From: Andrew Leon
Sent: Tuesday, February 21, 2023 8:25 AM
To: Ryan Harriman
Subject: FW: Totally Against DSR22-014 Baskin Robbins Proposed 10-unit building

From: Sarah Fletcher <fletchsa1@gmail.com>
Sent: Sunday, February 19, 2023 7:04 PM
To: Andrew Leon <andrew.leon@mercerisland.gov>; Jeff Thomas <jeff.thomas@mercerisland.gov>; Planning Commission <Planning.Commission@mercergov.org>; Design Commission <Design.Commission@mercergov.org>
Subject: Totally Against DSR22-014 Baskin Robbins Proposed 10-unit building

Hello, I want the owner to know that I am totally against his proposed 10-unit apartment building and to let the owner know that his proposed apartment building is more for investment purposes, rather than what is good for our community. What connection he/she has to Mercer Island. Any?

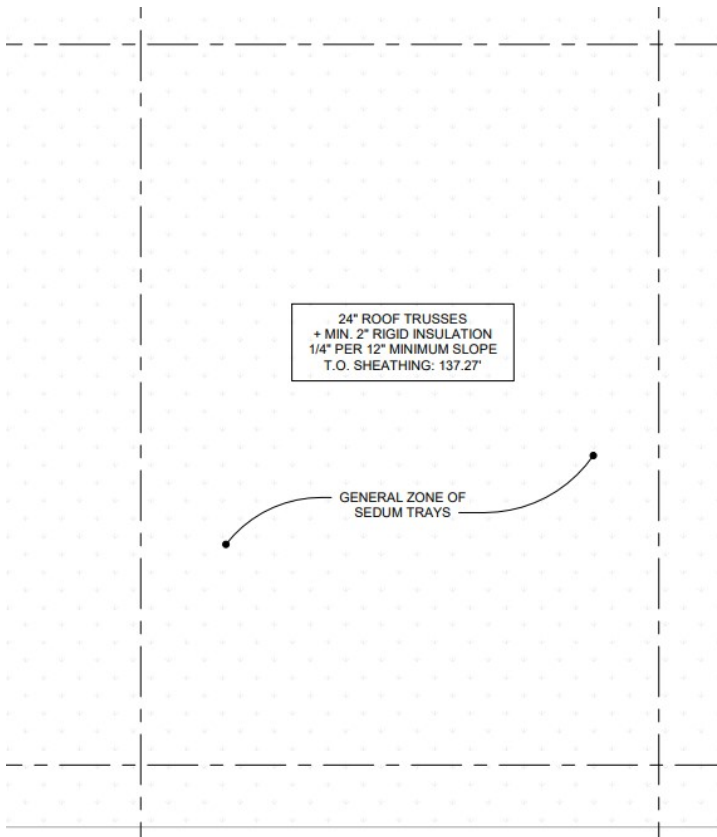
It says that 3,250 sf of sedum trays on the roof, but if you look at the plans on page 7, it does not show 3,250 sf of sedum trays, it shows a portion. And are you trying to say, that they can go across the road, buy a few trays of sedum and put them on the roof, and that is sufficient?

As I am a layman and don't know how to read plans, how much exactly is it showing? I

If you look at the plans, it has a section of the roof as for the sedum trays on a portion and not even on the whole roof, I doubt very much it equals 3,250 sf of roof space?

Trees #8-10

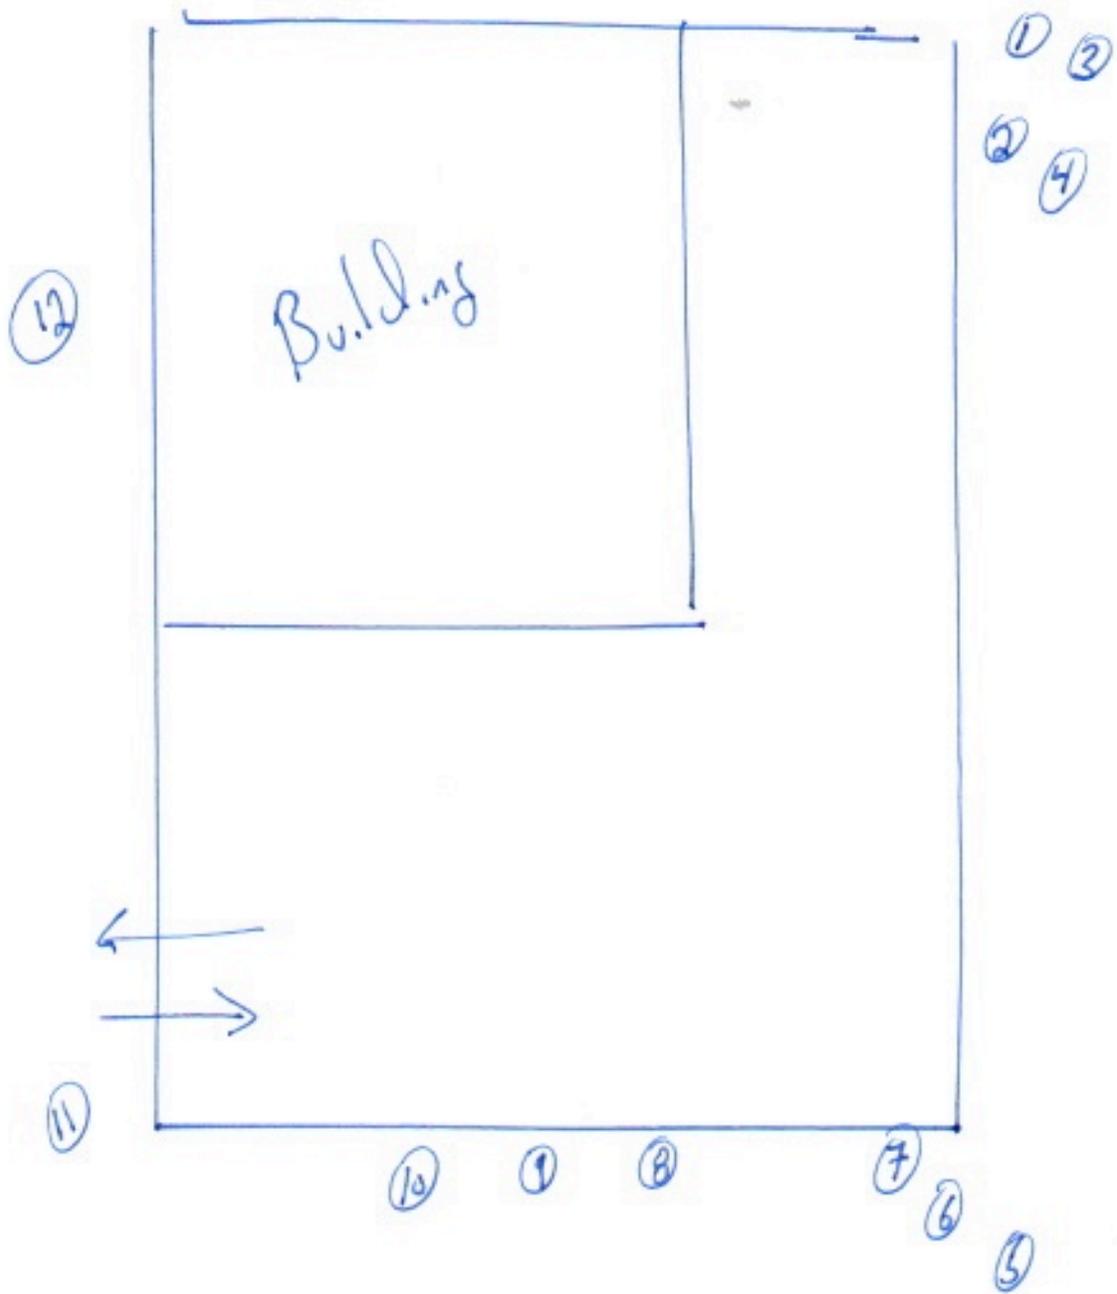
It states that trees 8 through 10 are to be removed, but if you look at the photographs, they are on City property, not even on the developer's property.

- a) What right do they have to remove any City trees regardless of whether they are significant or otherwise?
- b) Where does it say anything in the code that a developer can remove city-property trees? Please make sure that they do not remove any City right of way trees.
